KITTITAS COUNTY

DEPARTMENT OF PUBLIC WORKS

MEMORANDUM

TO: All Staff
FROM: Public Works Plan Review Team
DATE: November 3, 2022
SUBJECT: LP-22-00005 Suncadia Phase 2 Division 8

SHEET:
PP-03
 3 OF 6 SHEETS

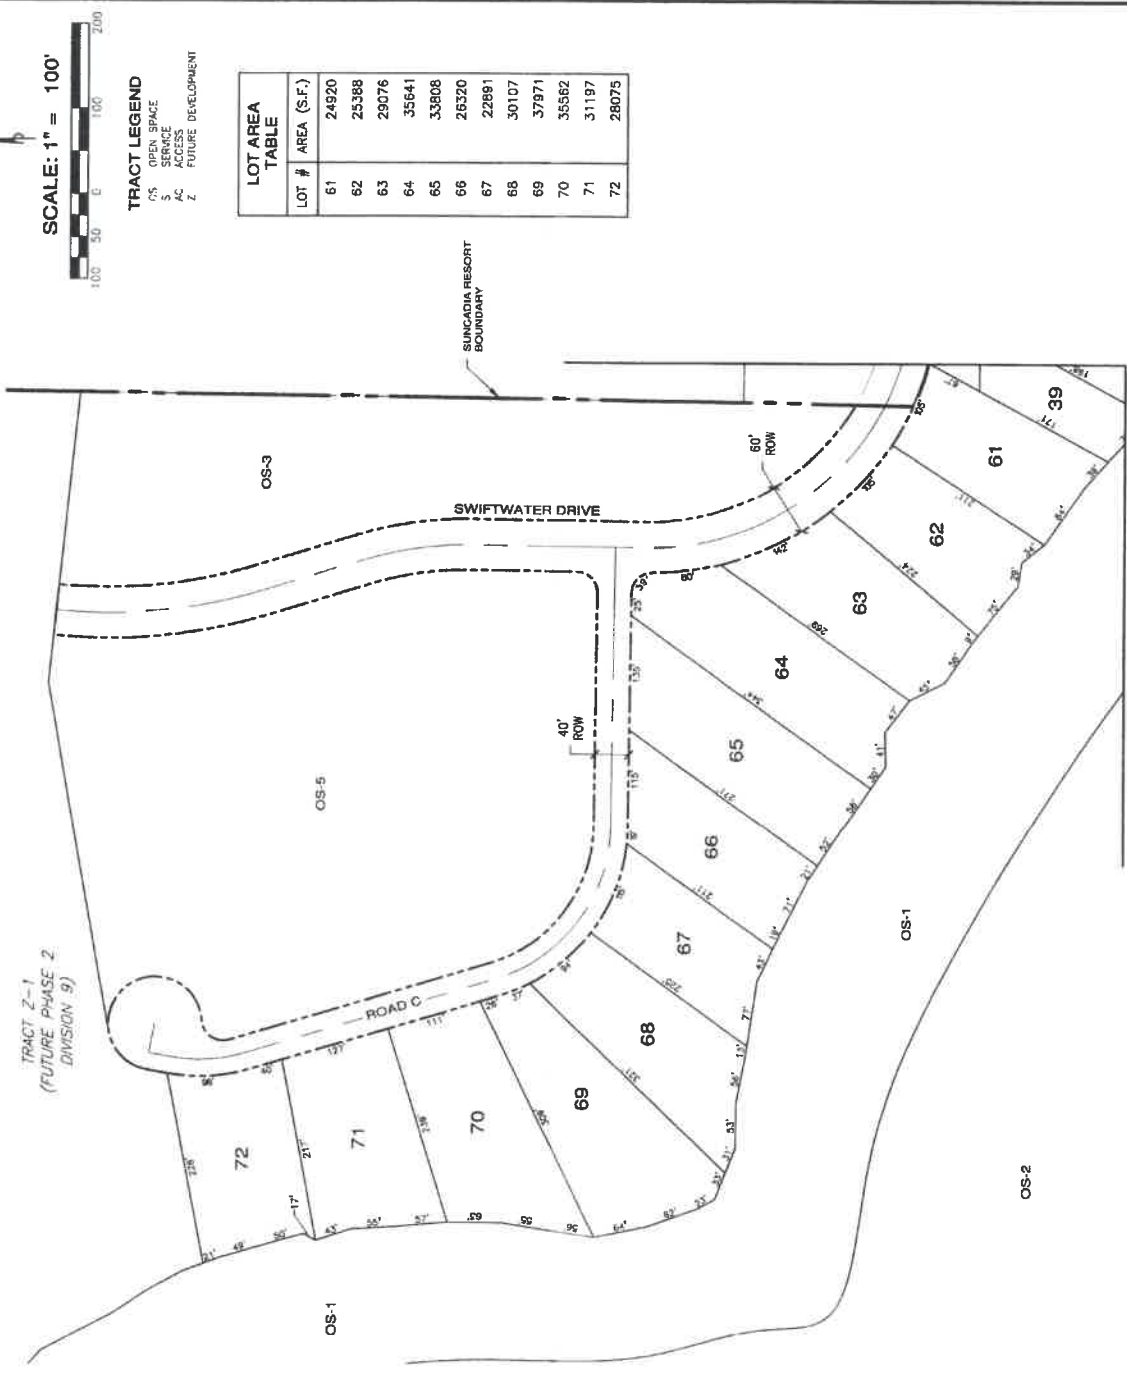
<ul style="list-style-type: none"> • Please provide an inventory of equivalent residential units, or the accounting method utilized in the water system plan, affirming sufficient capacity serving the plat. • Please provide an inventory of equivalent residential units, or the accounting method utilized in the general sewer plan, affirming sufficient capacity serving the plat. • A transportation impact analysis (TIA) shall be required for all development that will generate more than nine (9) peak hour vehicle trips. Please provide estimated traffic generation for peak hours to determine if a TIA will be required. (KCC 12.10.040(c))
ENGINEERING	<ul style="list-style-type: none"> • A civil review will be required through Public Works.
SURVEY	<ol style="list-style-type: none"> 1. Name of Subdivision at top center of page. (All Sheets) 2. include Engineer of Record. (Sheet 1) 3. Include area labels or tables for all Open Space, Service and Future Development Tracts. (All Sheets) 4. For existing roads, include ownership, width, and surfacing. (EX: Swiftwater Drive – 60’ wide private R/W – Paved) 5. For all ROW’s identify if there are Existing or Herein Dedicated. (All Sheets) 6. Identify Swiftwater Drive, Winston Road, and Bakers Road as topo features in Section 11. No dimensioning or ROW creation needed. (Sheet 6) 7. Show and Label Cle Elum River. (Sheet 6)

FLOOD	<p>A portion of parcels 11839, 11840, 11841 and 11842 are located in the FEMA identified special flood hazard area (100-year floodplain). Per KCC 14.08.220, all subdivisions shall show on the face of both the preliminary and final plat, for either short or long plats, the boundary of the 100-year floodplain and floodway.</p> <p>Prior to plat approval the 100-year floodplain boundary must be included on the face of the plat.</p>
WATER MITIGATION/ METERING	No comments
